CITY OF MERCER ISLAND

INTAKE SCREENING MEETING PACKET

DATE	10/10/17	TIME	2pm	Permit #		1 st Screening	<input checked="" type="checkbox"/>	2 nd Screening	<input type="checkbox"/>
PROJECT ADDRESS	5236 W MW								
OWNER	MILLS								
APPLICANT NAME	JOSEPH GRIFF								
SCOPE OF WORK	CONSTRUCT NSFR ON VACANT LOT								
<input type="checkbox"/>	Commercial Project								
<input checked="" type="checkbox"/>	New Single Family Residence								
<input type="checkbox"/>	Long Plat/Short Plat								
<input type="checkbox"/>	Remodel/addition project with 500 net square feet (or more) increase in impervious surface								
<input type="checkbox"/>	Remodel/addition project with less than 500 net square feet increase in impervious surface								
<input type="checkbox"/>	Redevelopment project (where greater than 40% of the exterior building walls will be structurally altered, the entire project will be designed as if it were a new SFR being constructed on a vacant parcel).

*PRE - 17-029
 updated 10/10/17*

5236 W MERCER WAY
SINGLE FAMILY RESIDENCE
TREE PRESERVATION PLAN

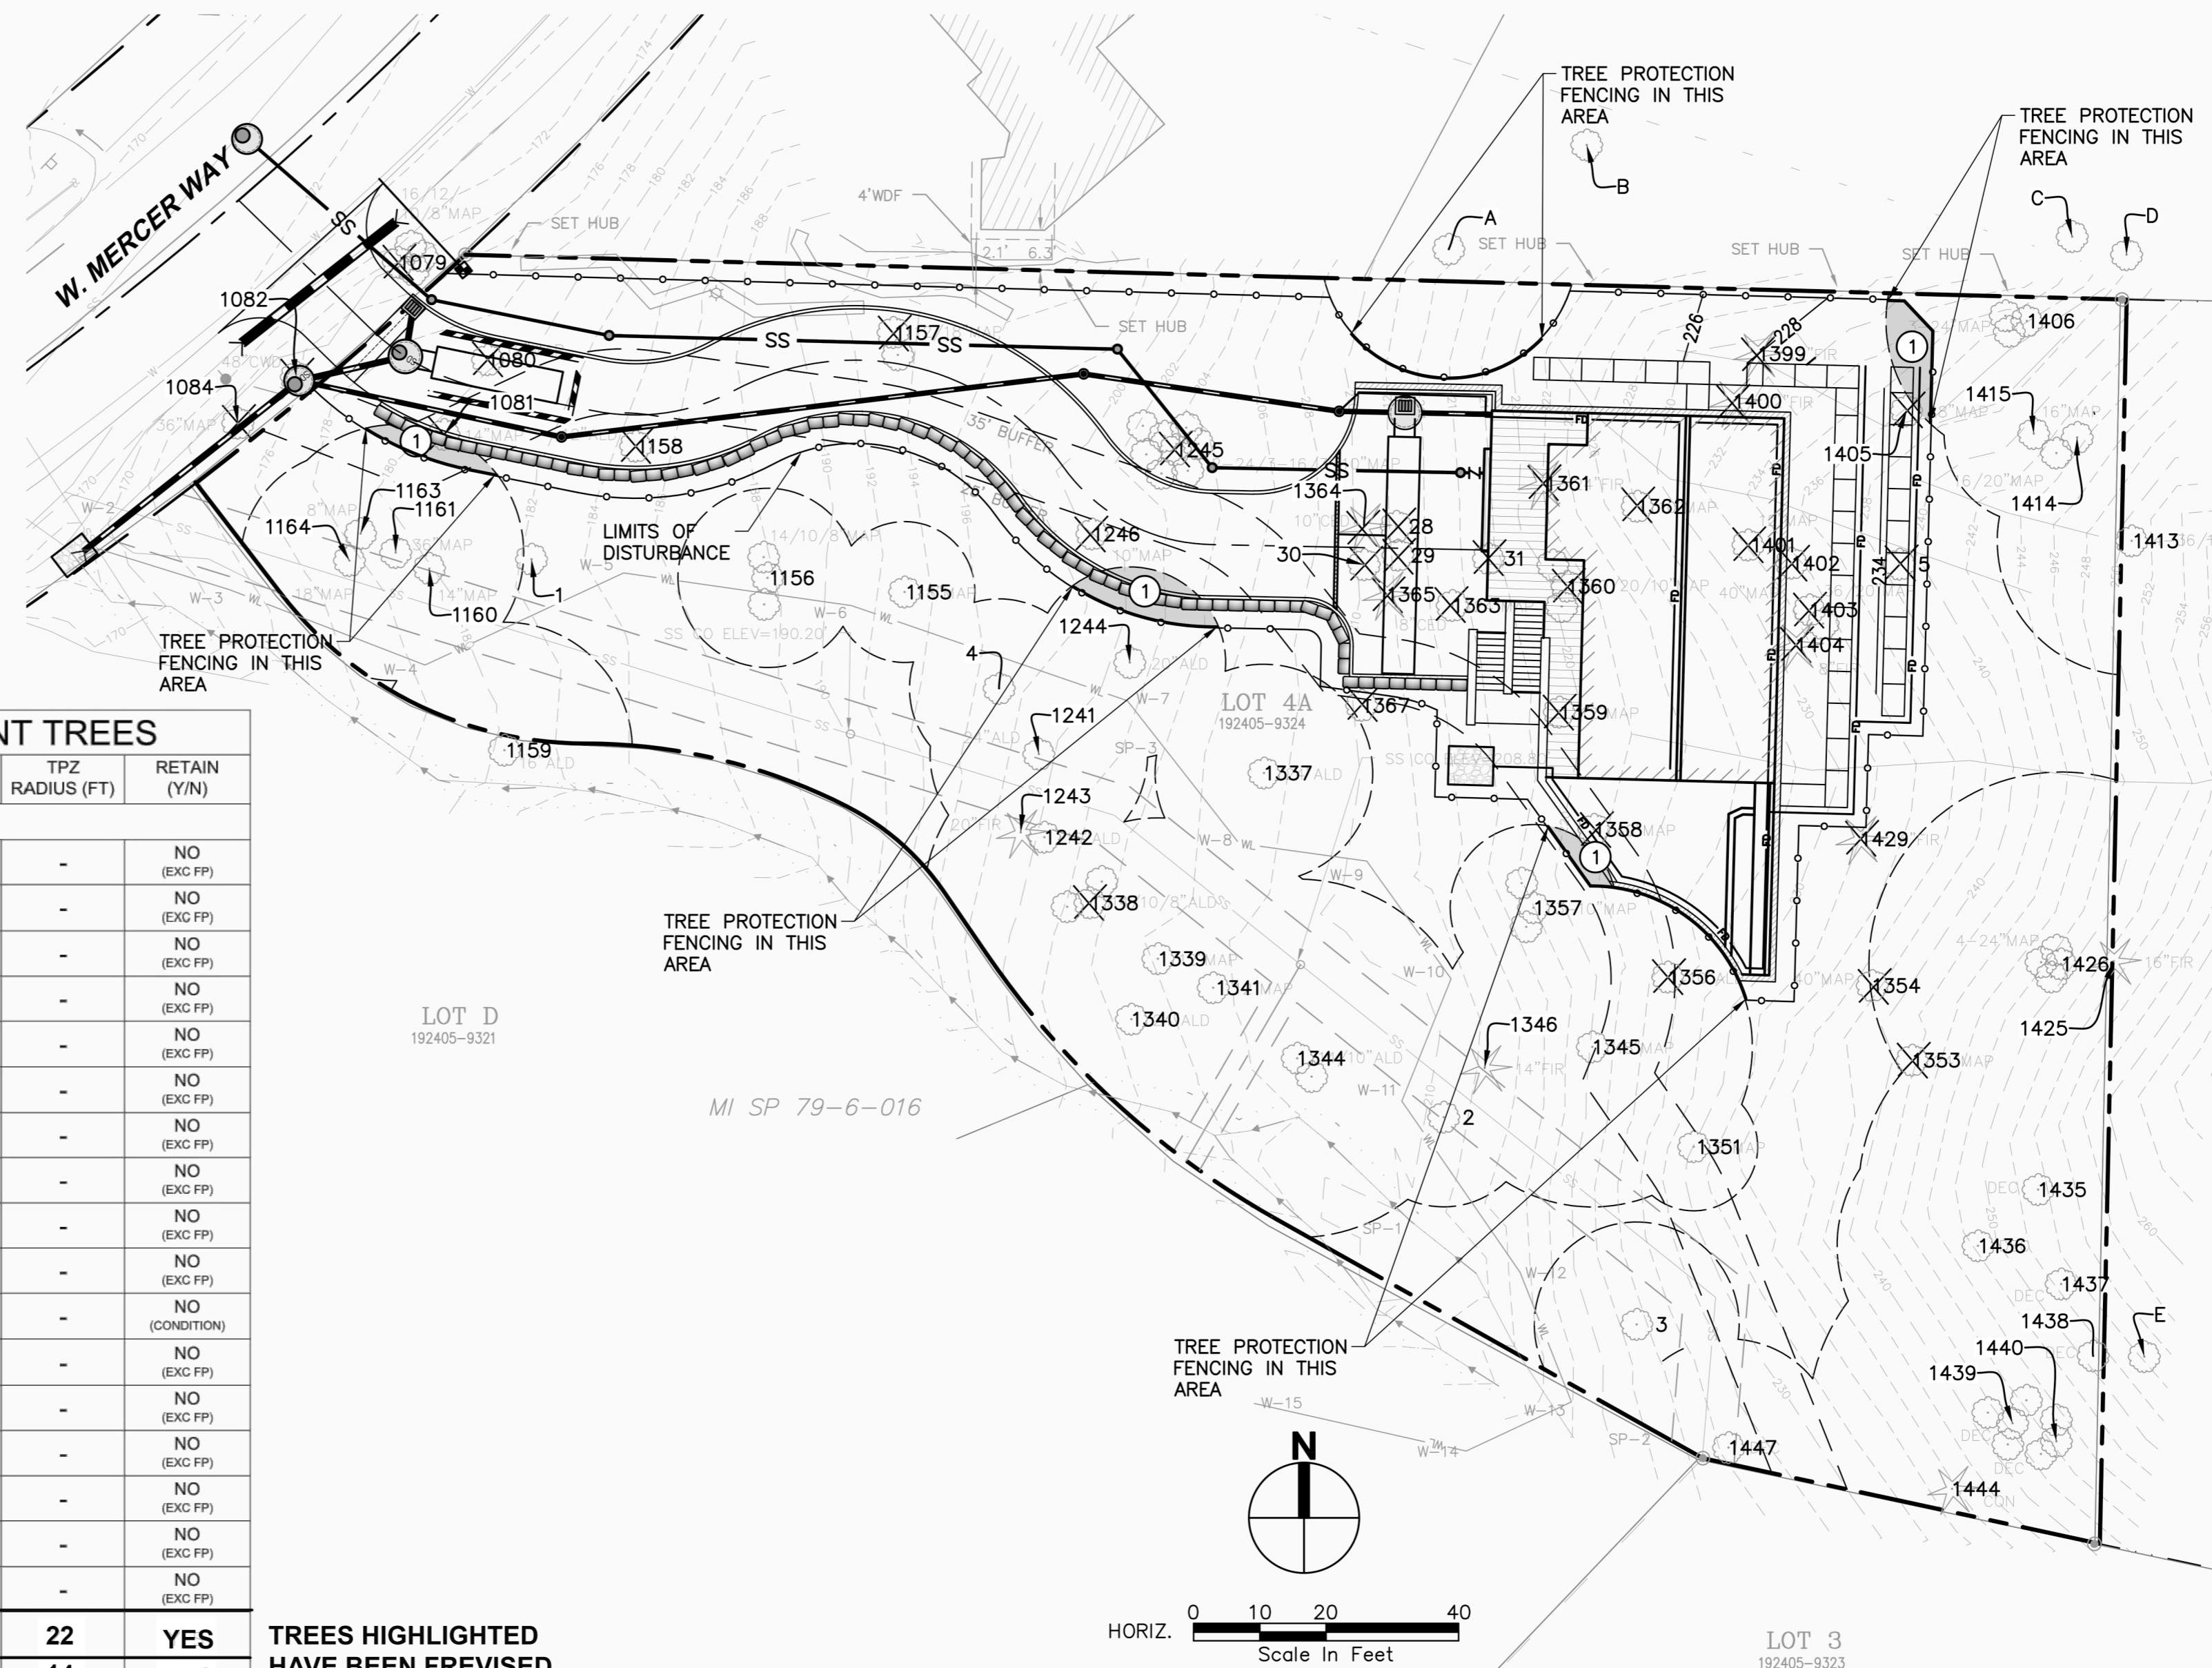
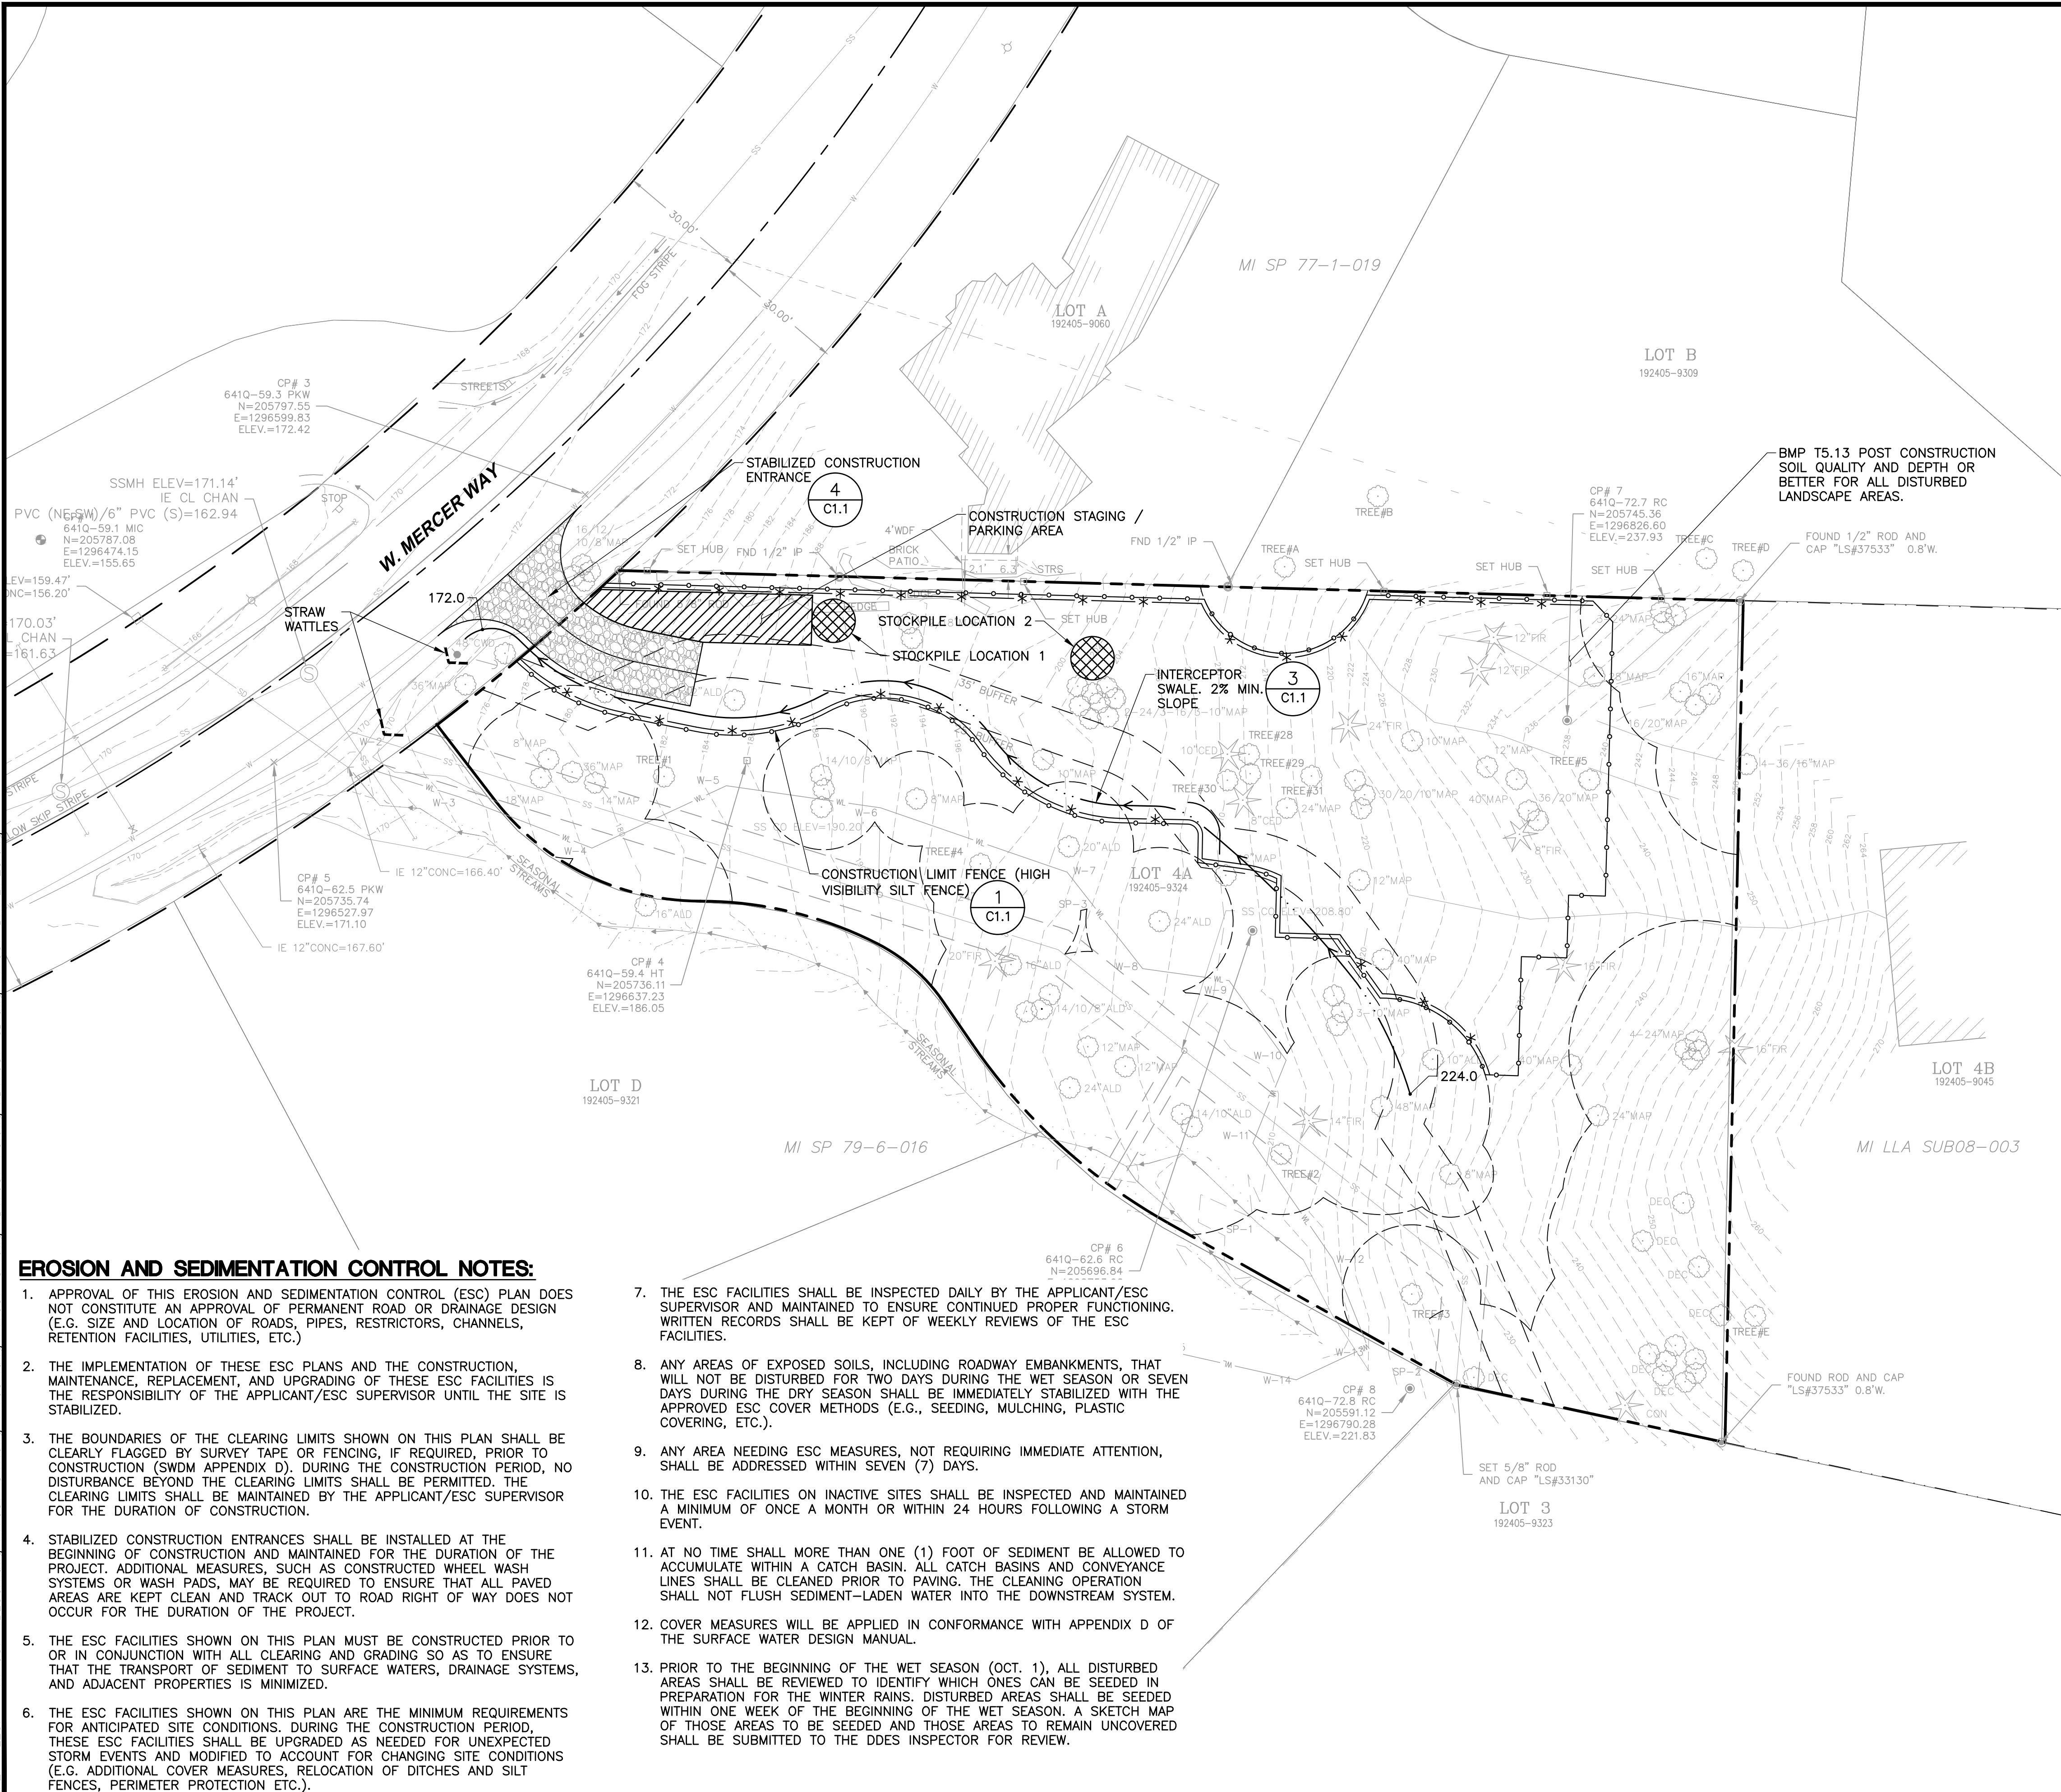
- Provide an arborist report:
complete report, gave preliminary
Arborist
- Indicate the following on the Utility/Civil plan sheets:
 - Location, species, and diameter of all Regulated Trees (6 inches dbh for deciduous and 6 feet tall or taller for evergreen).

- Location, species, and diameter of all Regulated Trees in the right of way adjacent to the site. These trees are owned by the City and protecting them is a priority. Garages, driveways, utilities, and other improvements shall be designed to avoid these trees and their roots.

- The approximate size and location of all Regulated Trees within 15' of property boundary.
 - Number trees on plans for easy identification of individual trees to be saved and/or removed.

- Show drip lines of Regulated Trees to scale. TBZ + noted distance from tree per report.
 - Show tree protection fencing around all Regulated Trees at drip lines.

- Use reasonable best efforts to design the home, driveway, underground utilities and other proposed improvements in a manner that provides for reasonable development while minimizing impacts to Regulated Trees on site and in the right of way. Conduct all work in accordance with best construction practices to retain as many trees as possible.

5 BACKFLOW PREVENTION VALVE
NTS

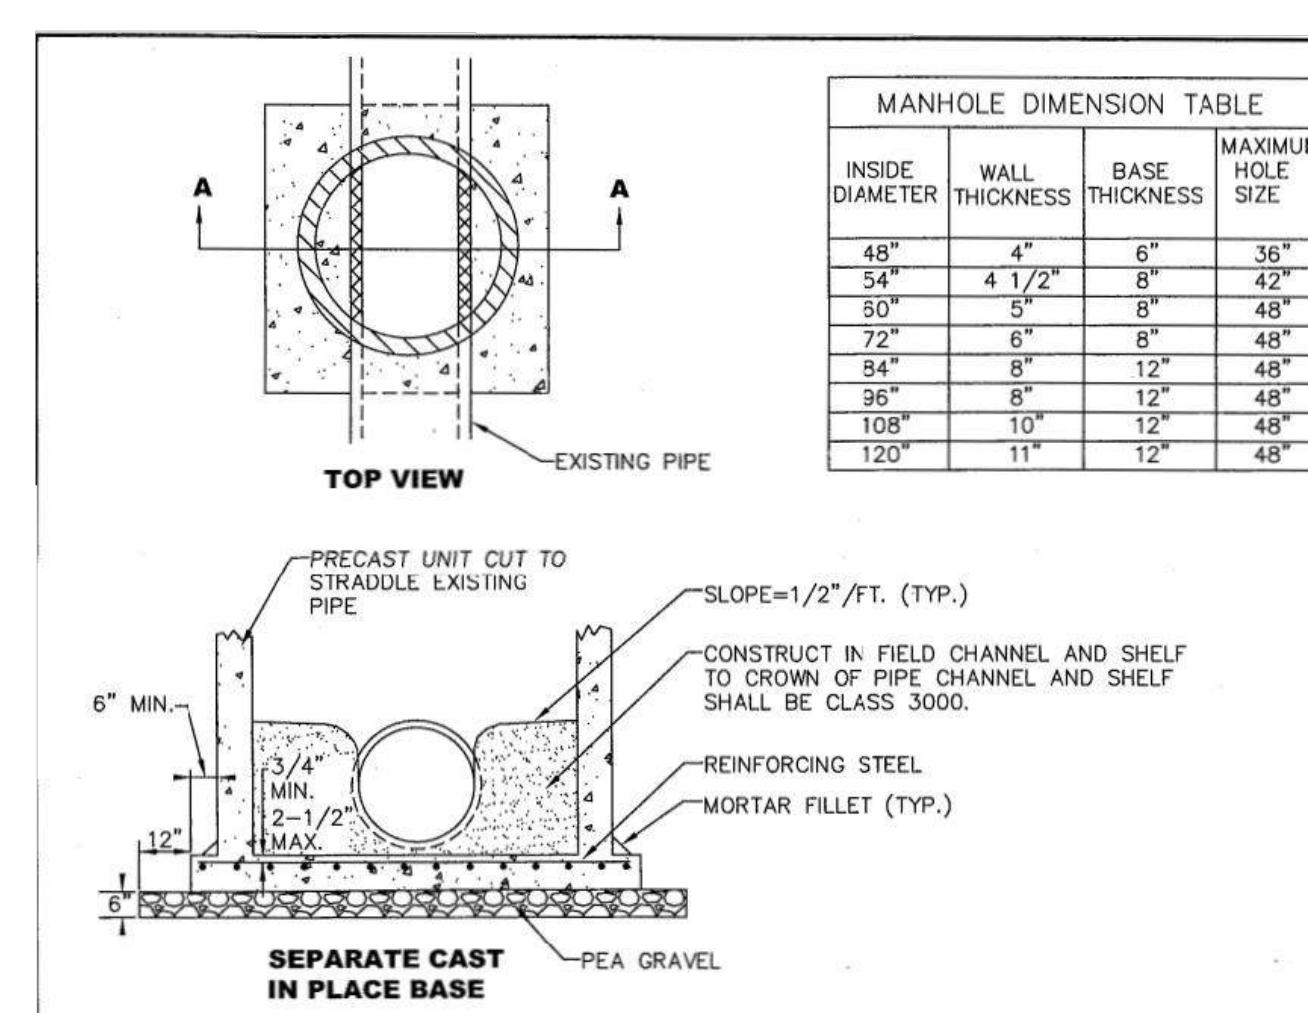
<input type="checkbox"/>	Sanitary sewer main extension/modification required.	<input type="checkbox"/>
<input checked="" type="checkbox"/>	The side sewer is shared and requires a backflow prevention valve.	<input type="checkbox"/>
<input type="checkbox"/>	Provide the layout of the new side sewer from the residence to the point of connection at the main. Shared side sewers shall be clearly labeled. The layout shall include material, slope, distance to existing trees and easements (if applicable).	<input type="checkbox"/>
<input type="checkbox"/>	The existing side sewer is a shared side sewer within a private easement. A copy of the recorded easement is required prior to issuance of the building permit.	<input type="checkbox"/>
<input type="checkbox"/>	Water front properties that have a side sewer connection to the public main in Lake Washington must have a backflow prevention valve installed outside of the building. Show the proposed location of this valve on the utility plan.	<input type="checkbox"/>

Notes
added
to Civil
Drw's
